**RESPONSE TO REQUEST FOR ADDITIONAL INFORMATION
SSD 49295711 MOD 2 – HARBOURSIDE SHOPPING CENTRE REDEVELOPMENT – SSDA 2**

This letter has been prepared by Ethos Urban on behalf of Mirvac Retail Sub SPV Pty Ltd (Mircac) in response to items raised by the Department of Planning, Housing and Infrastructure (DPHI) in the Request for Additional Information (RFI) for SSD 49295711 MOD 2, dated 19 September 2024.

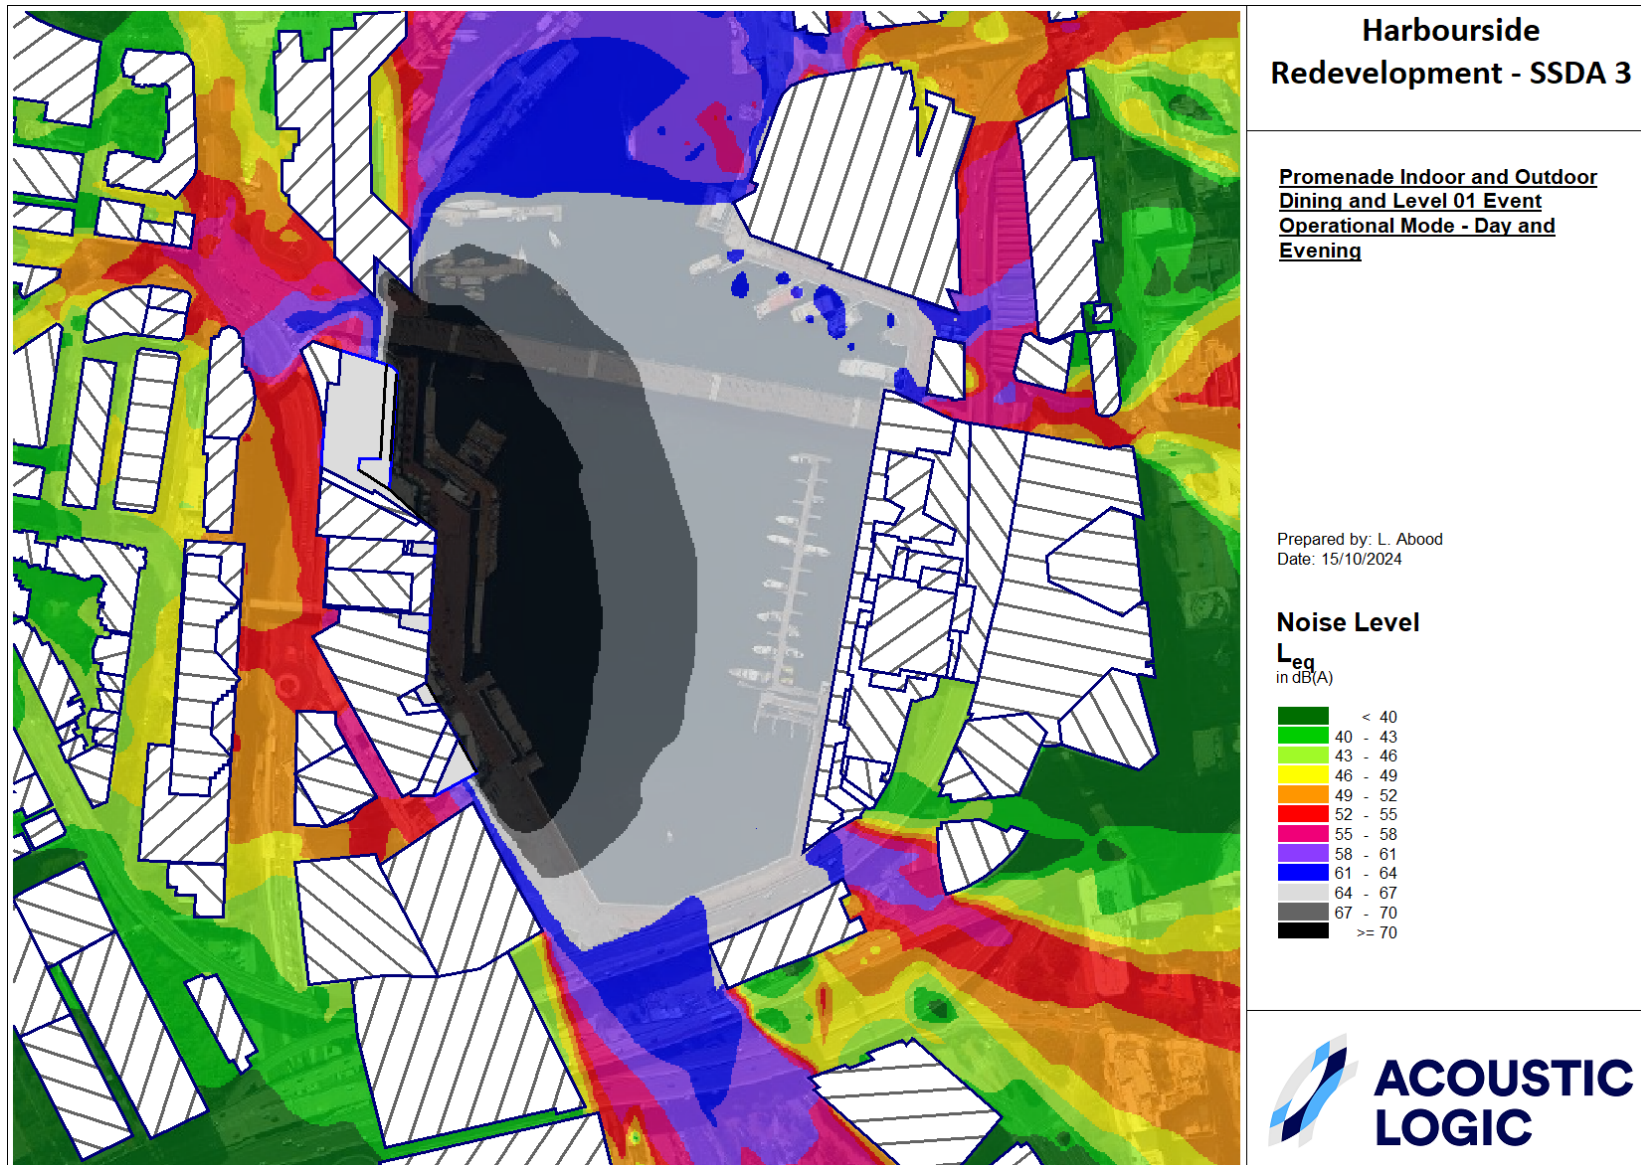
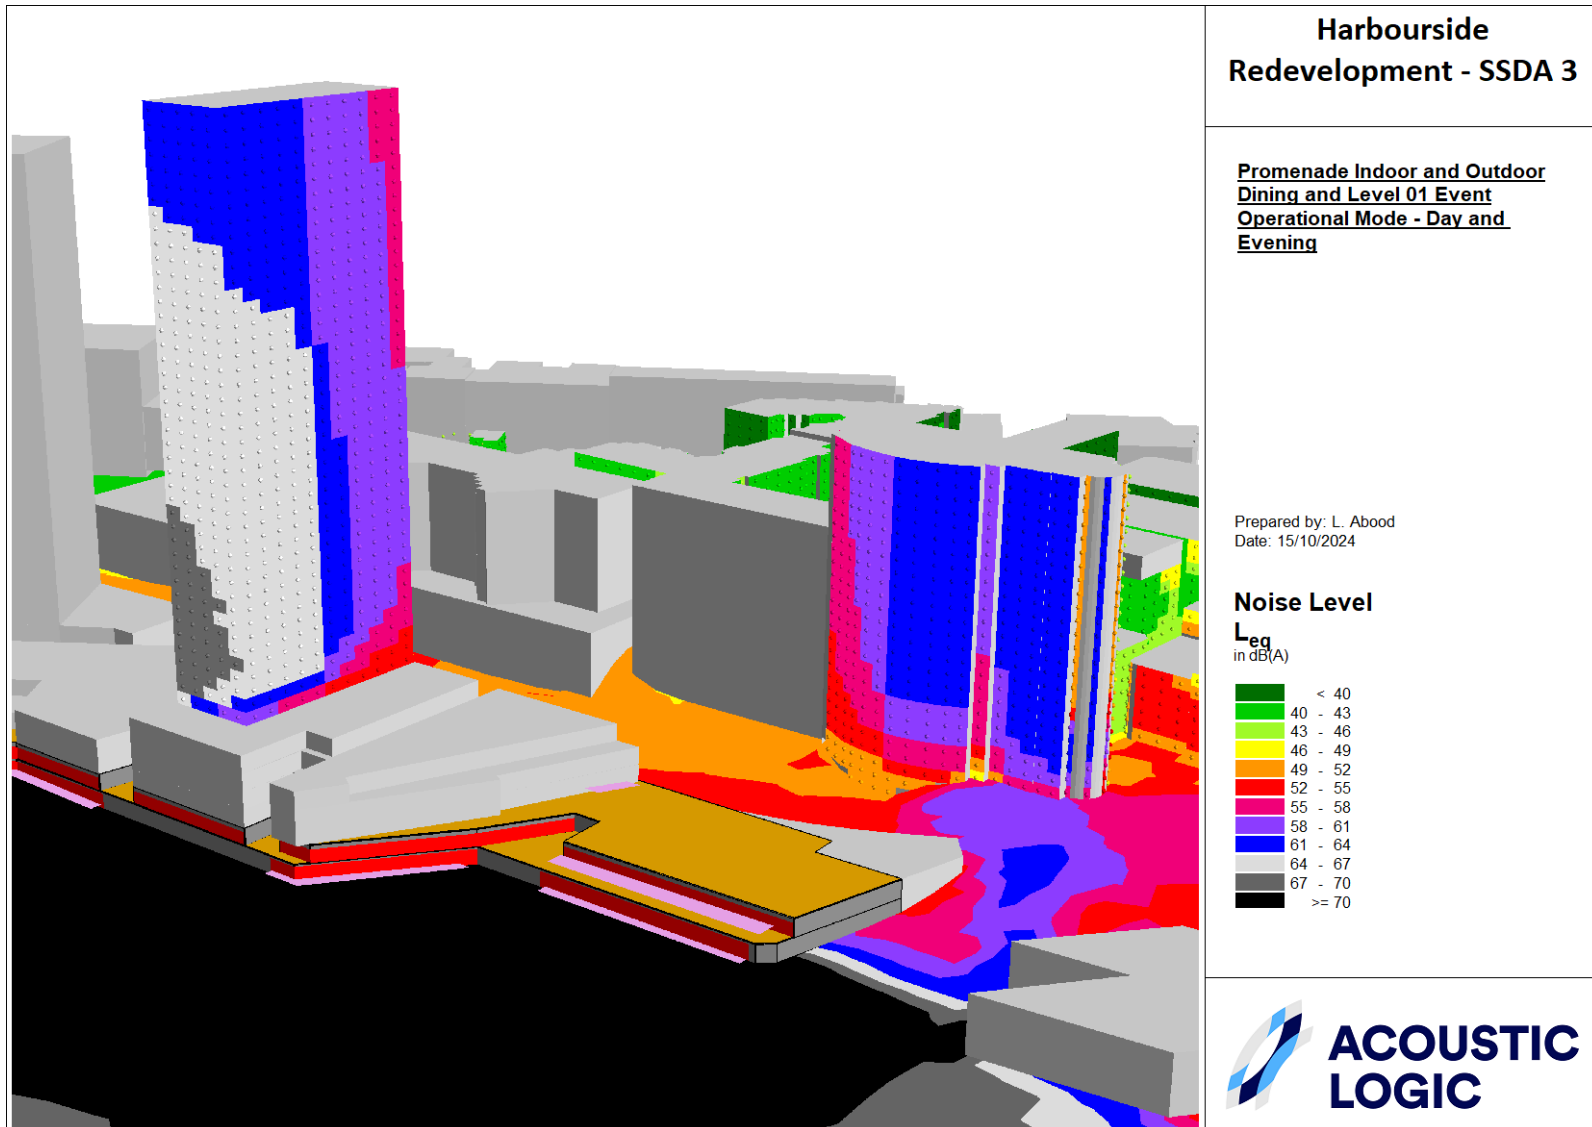
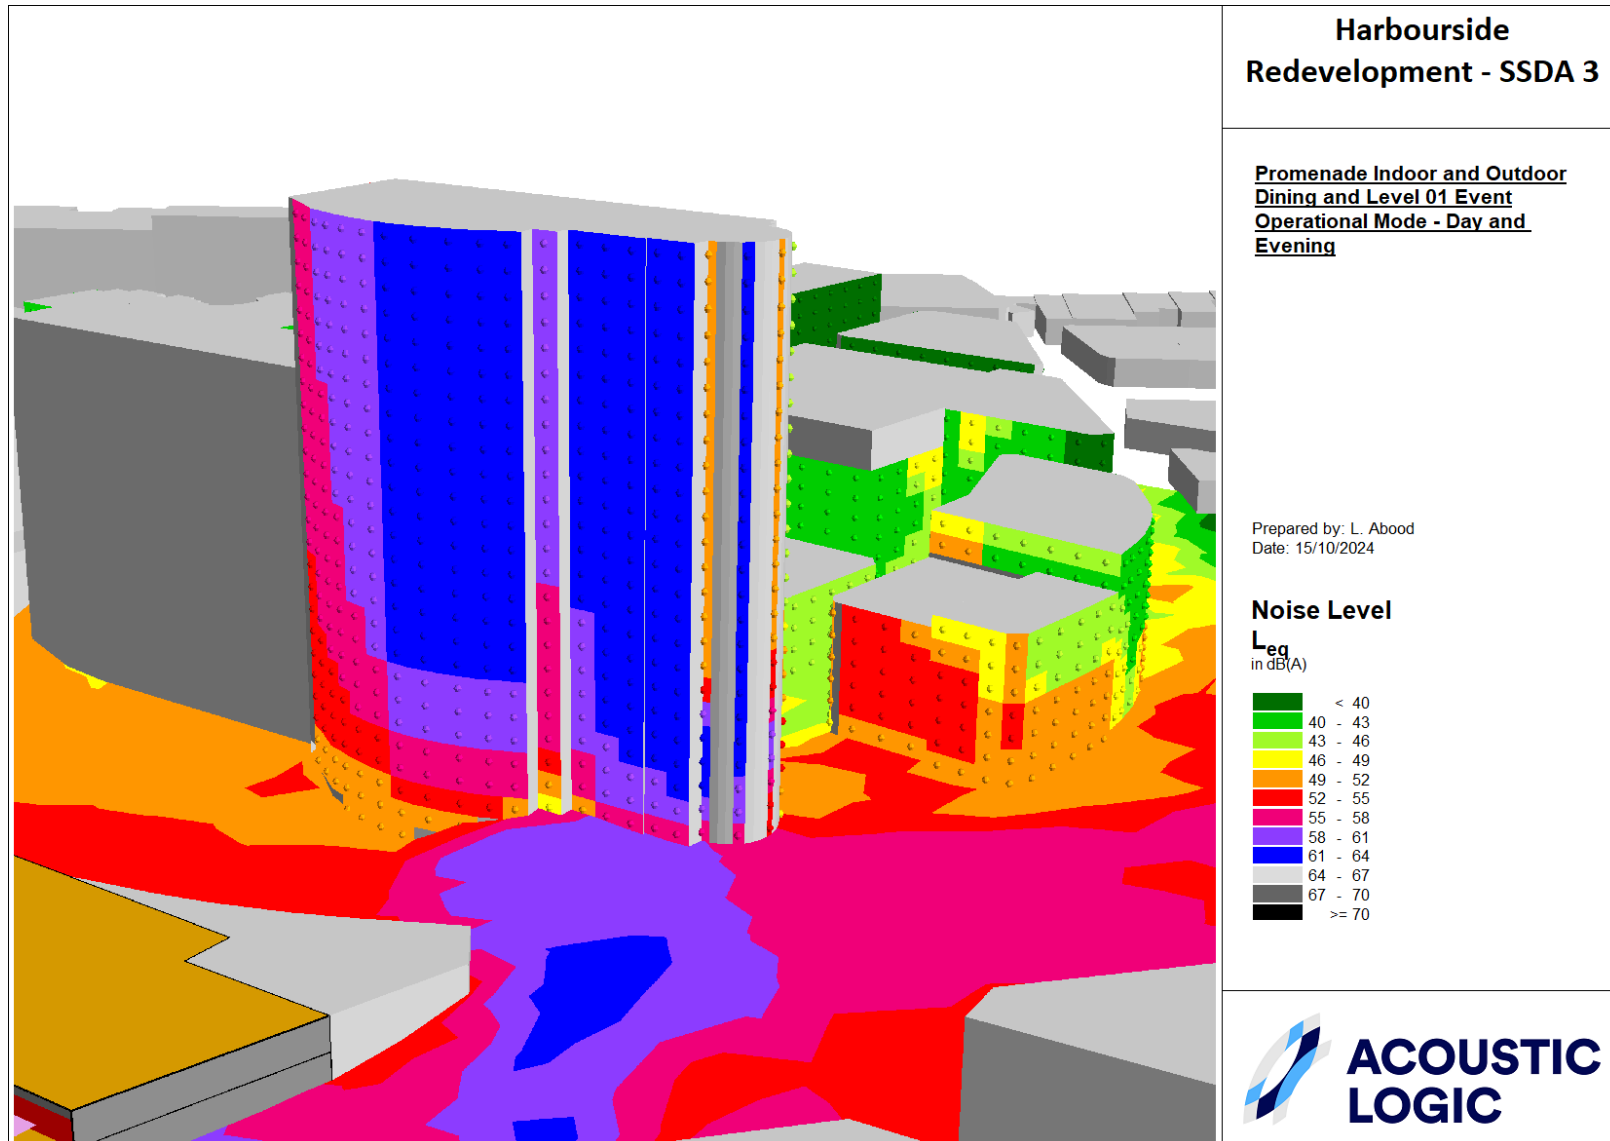
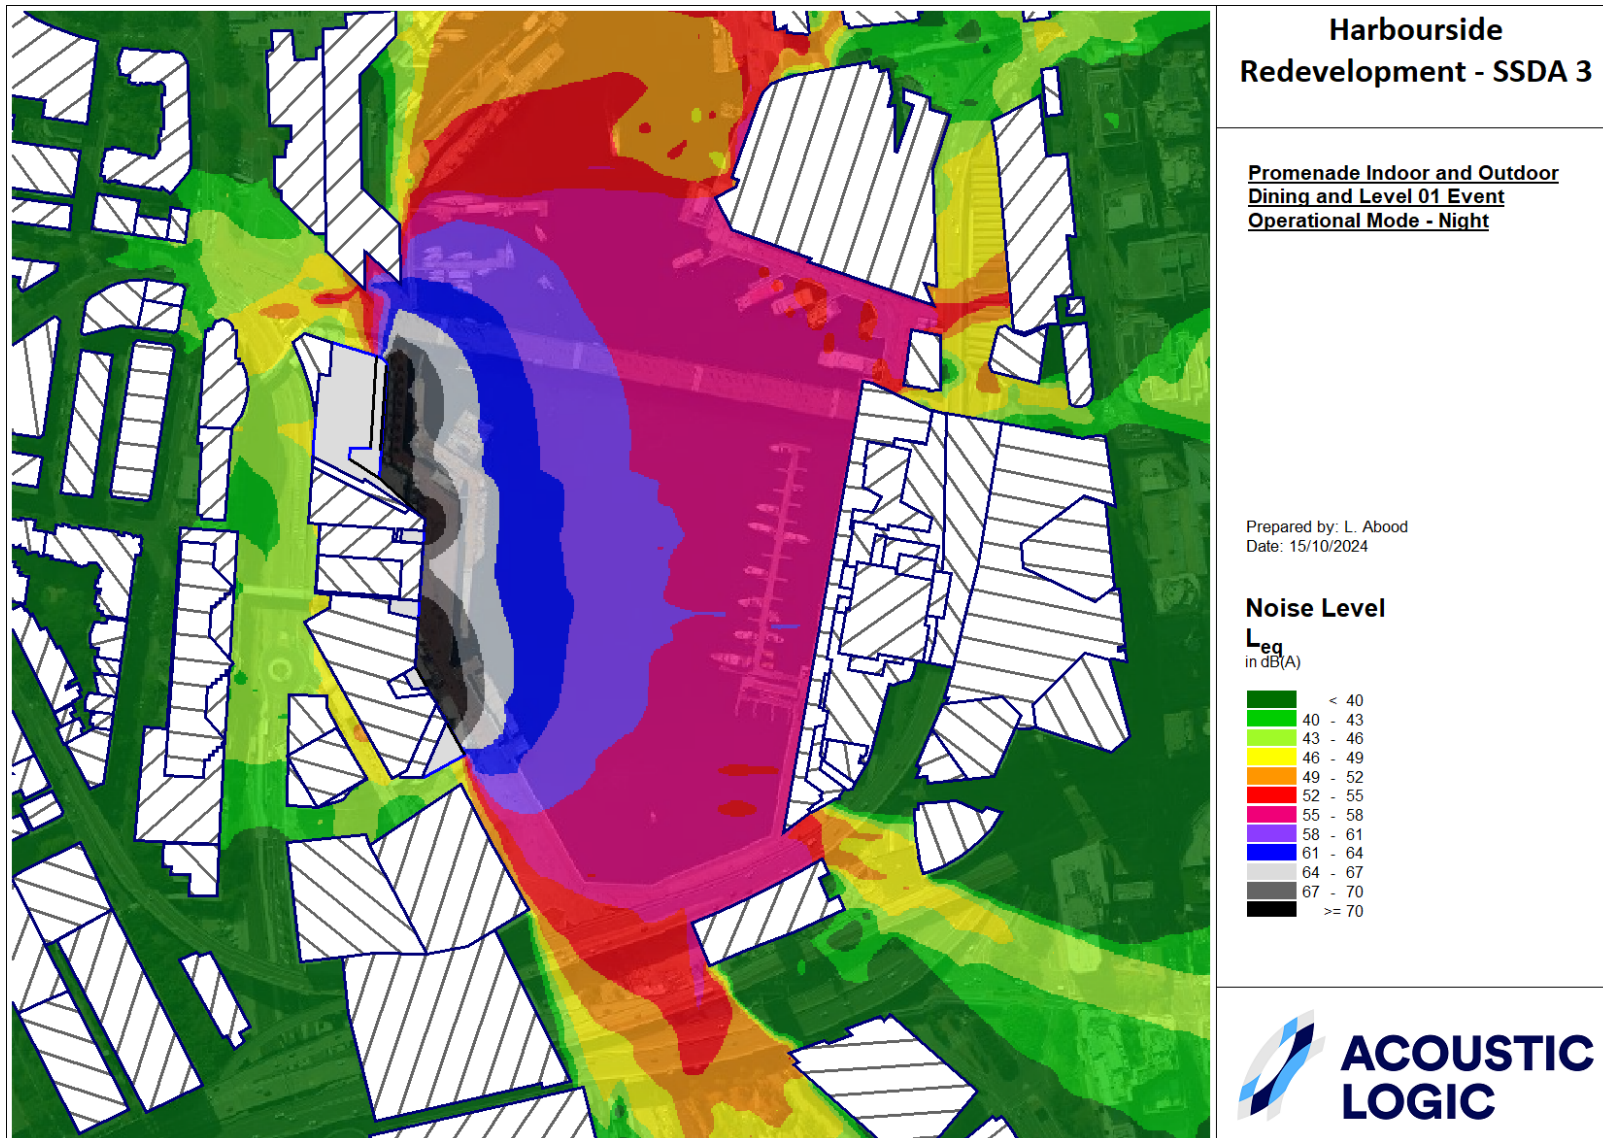
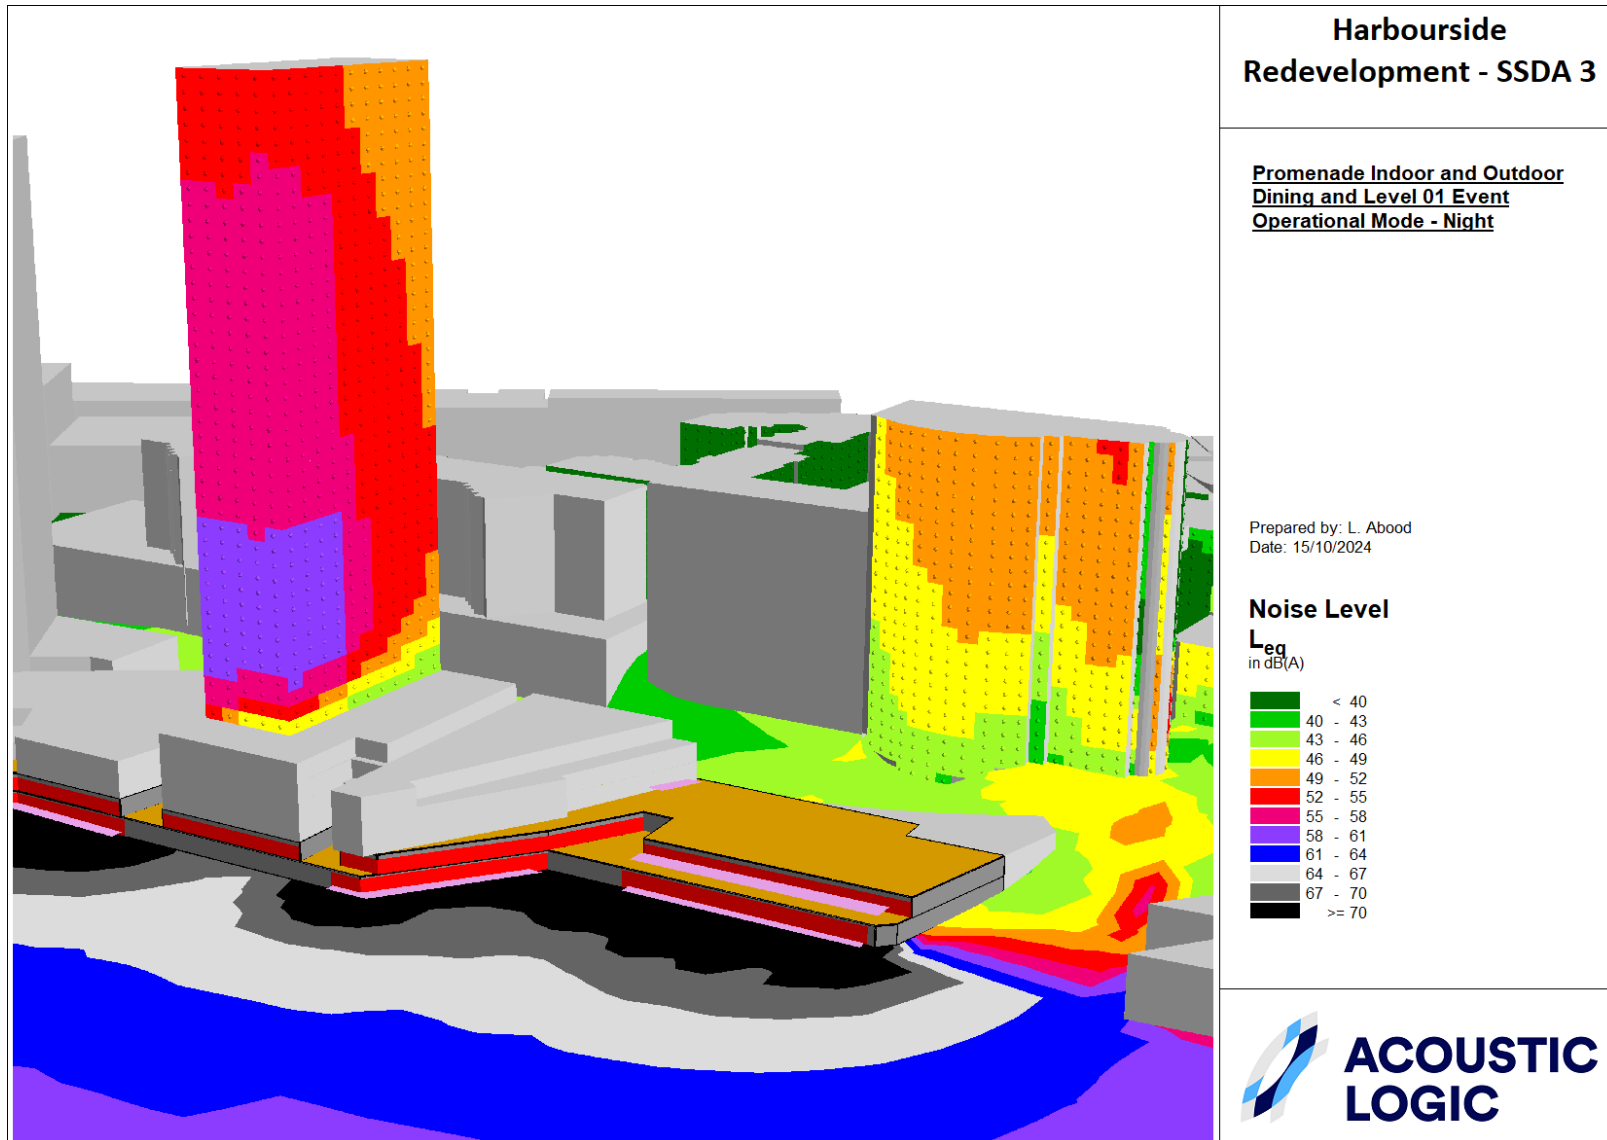
4. Acoustic impacts	
The applicant is proposing an event and conference centre on level one which is in addition to the previously allowable commercial space. The City is concerned that this area will generate a large volume of patron noise and noise from amplified music should events take place which will then impact the future residents in the tower and	Acoustic Logic have undertaken further assessment of the proposal, including factoring in the proposed operable façade along the eastern elevation (refer to Attachment A).

Item	Proponent's Response
surrounding residents in the area. An acoustic statement has been submitted which has stated that the event and conference space is primarily located internally and that there is an operable facade during quieter periods. The City recommends that more information be provided to fully assess the impact on the surrounding environment to ensure that appropriate acoustic treatment is undertaken at design stage. The applicant is to assess the event and conference area at full capacity/worst case scenario and demonstrate if further acoustic treatment is needed to ensure noise sensitive receivers are not affected by the operation of this area. This is to be assessed against the City's standard 'noise entertainment condition'.	Acoustic Logic confirm that the absolute worst-case usage of the Level 1 conference and event use complies with relevant NSWL&G standard noise conditions at the nearest noise sensitive receivers during daytime and evening periods (Between 7am and 10pm). Mitigation measures are required to be implemented between 10pm and 12am, where the eastern façade is required to be closed in instances where live music is laying, in order to achieve relevant acoustic requirements at surrounding receivers.
